The Drovers Solar Farm

Appendix 12.1: Consultation and Legislation, Planning Policy and Guidance

Table 12-1 Relevant Scoping Opinion Comments from Statutory Bodies relating to Water Resources

Table 12-2 Responses to the PEIR relating to Water Resources

DRAWING TITLE:
ES Figure 12.2 Indicative Watercourse Crossing

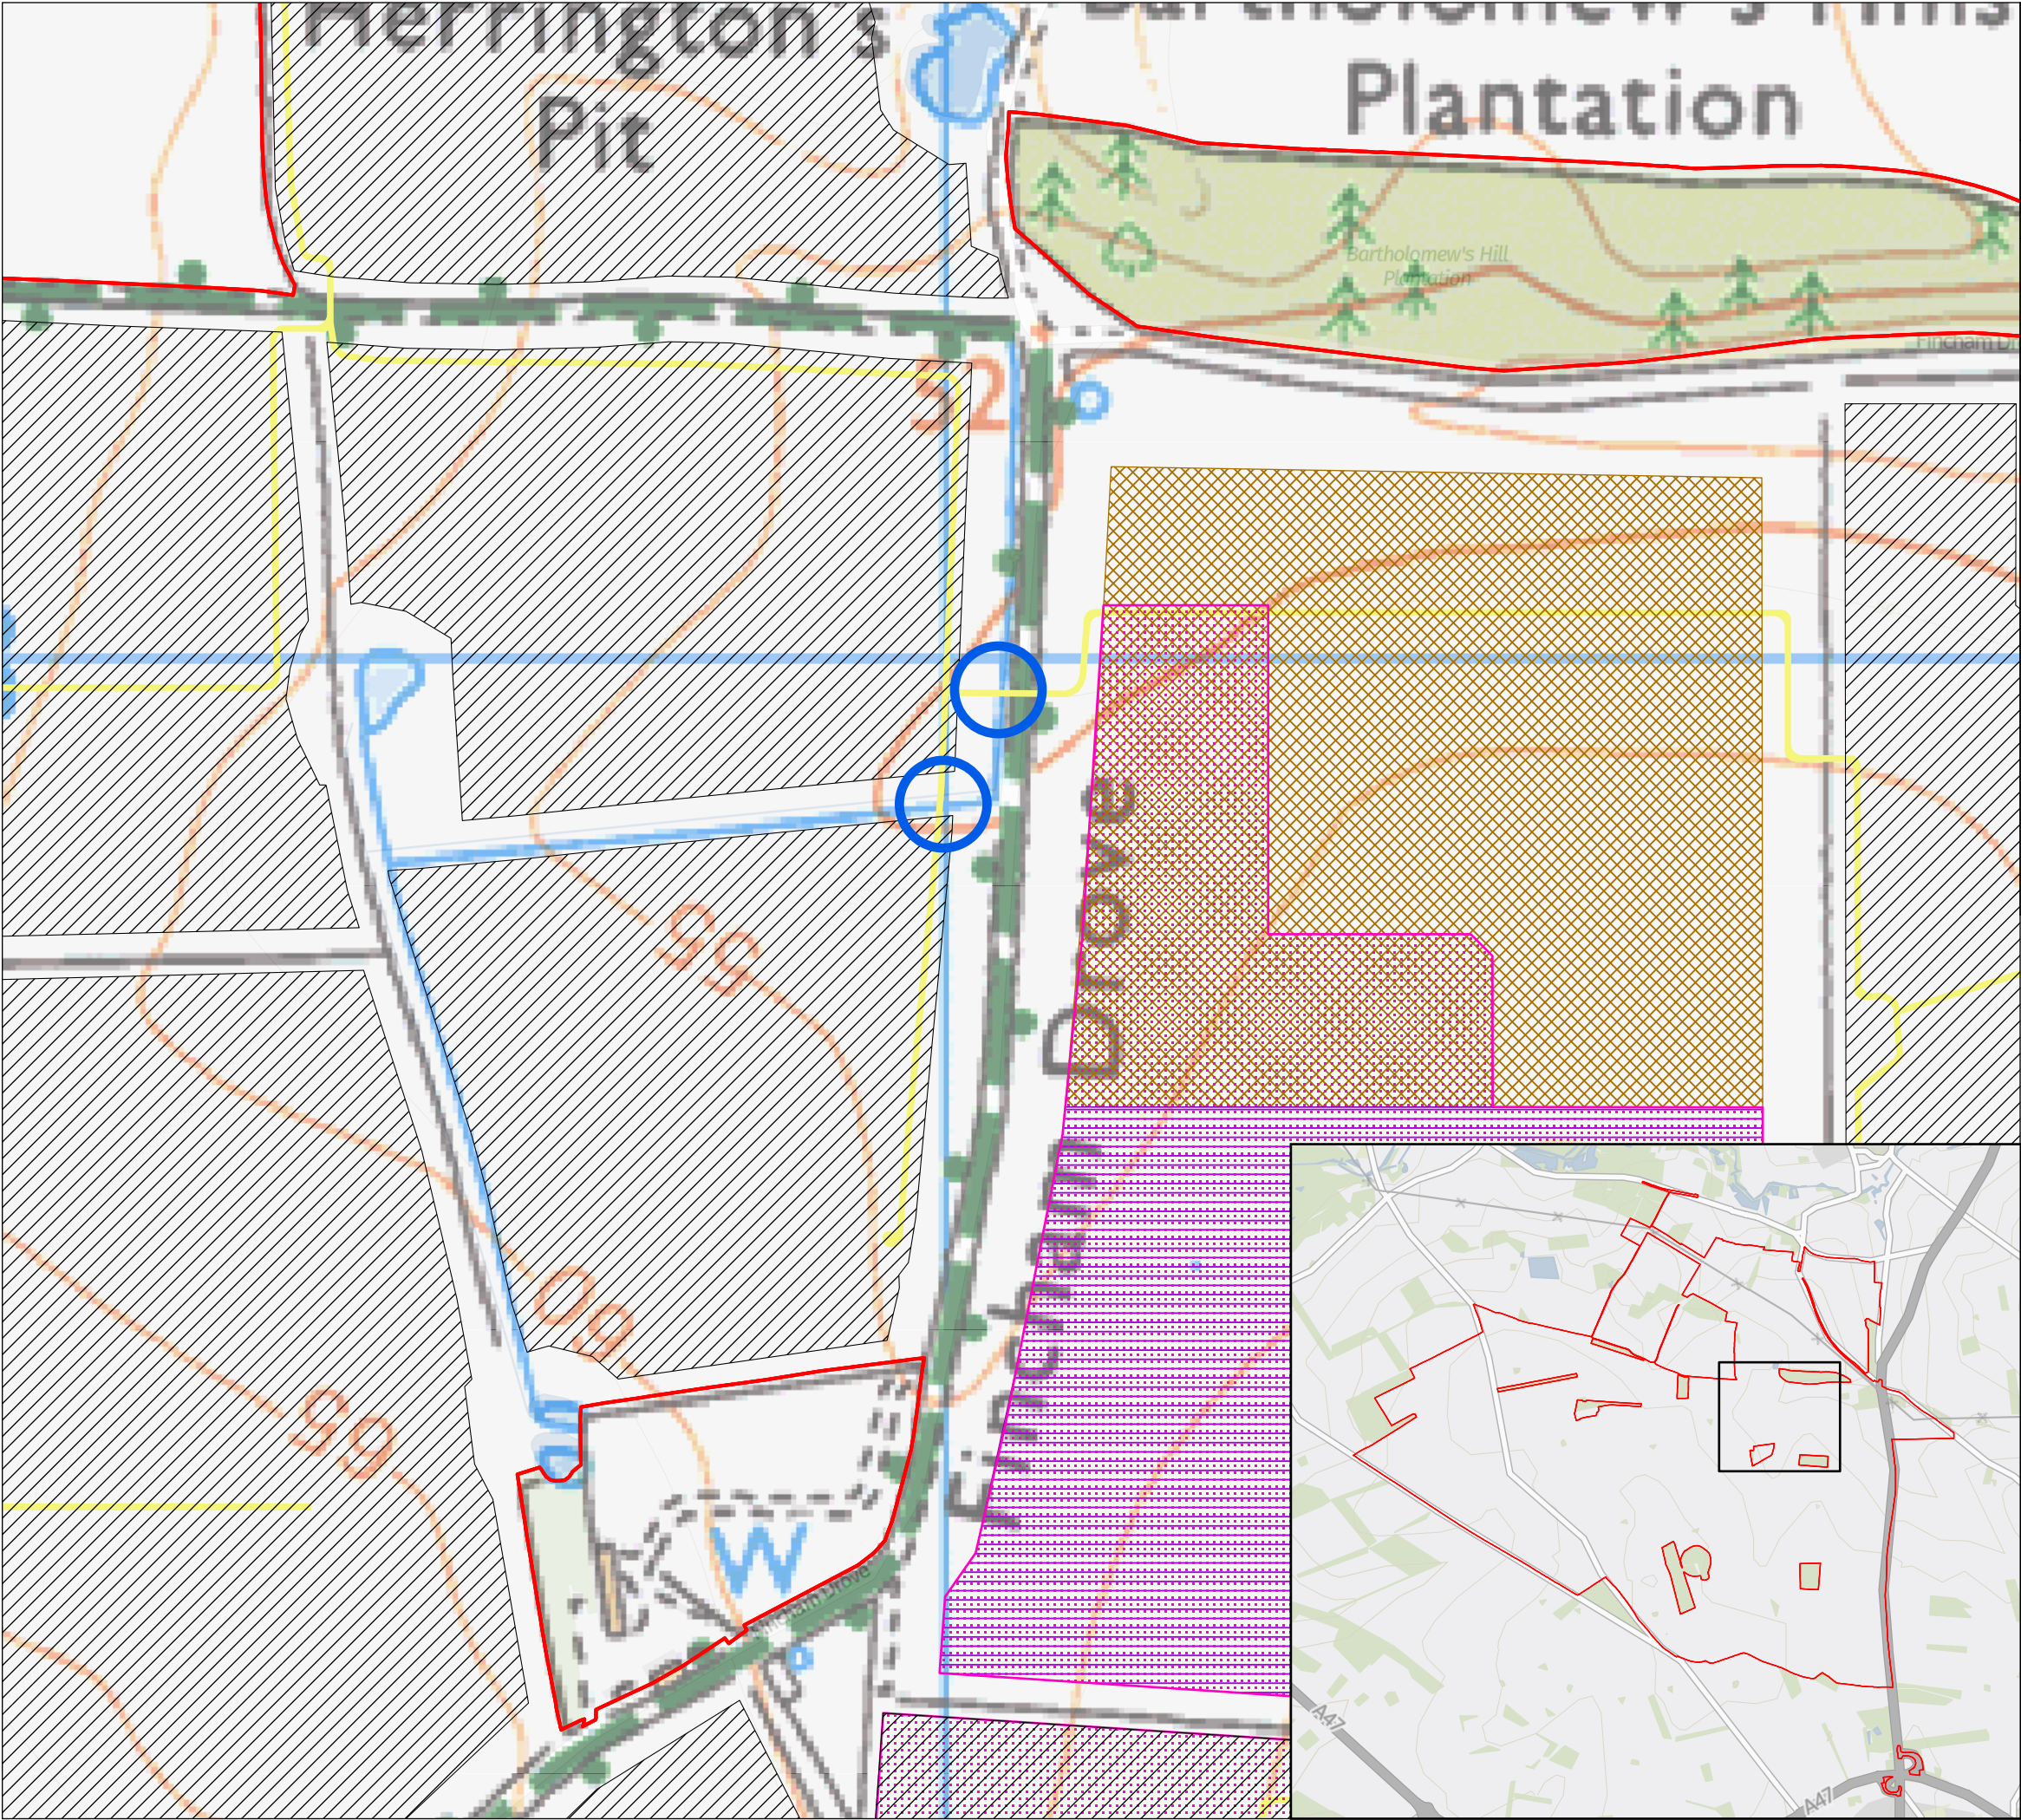
reminds the applicant that compacted material is considered impermeable and sustainable surface water management will be required for these temporary compound areas and new or improved temporary and permanent access track.		
	As this development covers a large area, a phasing plan supported by a construction phase surface water drainage plan will also be required to demonstrate there is no increase in flood risk in the construction phase (further information is provided in the LLFA's Developer Guidance). Otherwise, the proposed development could be considered not in accordance with the principles of NPPF and sustainable drainage.	A phasing plan will be provided as part of the detailed design of the Scheme following granting of the DCO, once a construction contractor has been appointed.	N/A
	Please note, if there are any works proposed as part of this application that are likely to affect flows in a river or watercourse, then the applicant is likely to need the approval of either Norfolk County Council, the Environment Agency or the local Internal Drainage Board. In line with good practice, these organisations seek to avoid culverting where possible. For Norfolk County Council, the consent for such works will not normally be granted except	Regarding watercourse crossings, the design of the Scheme does not have sufficient detail to confirm the exact locations of crossings at this stage. However, it is anticipated that the Scheme will require two crossings of a 'blind' / dead end ditch, which is not classed as an Ordinary Watercourse or Main River and which falls outside of the EA or LLFA remit for approval or issuing of consent. In any event, the draft DCO [APP/3.1] contains protective provisions for the benefit of the EA and drainage authorities.	Figure 12-2 of ES Chapter 12: Water Resources [APP/6.2] .

as a means of access. It should be noted that this approval is separate from planning.	The crossing locations are shown on Figure 12-2.	
	The LLFA notes the requirement for construction compounds however, there is no indication of the approximate location and number of them to support the development of the proposed site. Furthermore, the LLFA notes that as the site is to have a lifespan of 60 years, yet the design life of the PV panels is approximately 25-40 years and the batteries are 15 to 20 years, these structures are likely to be replaced at least once but more likely twice during the scheme's lifetime. The LLFA queries whether the permanent maintenance compounds to facilitate these maintenance activities will be provided with an associated impermeable area. The LLFA will require clarification on the location, duration and the surface water drainage arrangements for each of these construction compounds is requested to be included in the submission.	Maintenance compounds are not required for the operational phase of the Scheme. The oCEMP [APP/7.6] outlines how SuDS will serve Temporary Construction Compounds.	See section 3.8 of the oCEMP [APP/7.6] , which is secured via requirement of the Development Consent Order (DCO) Application.
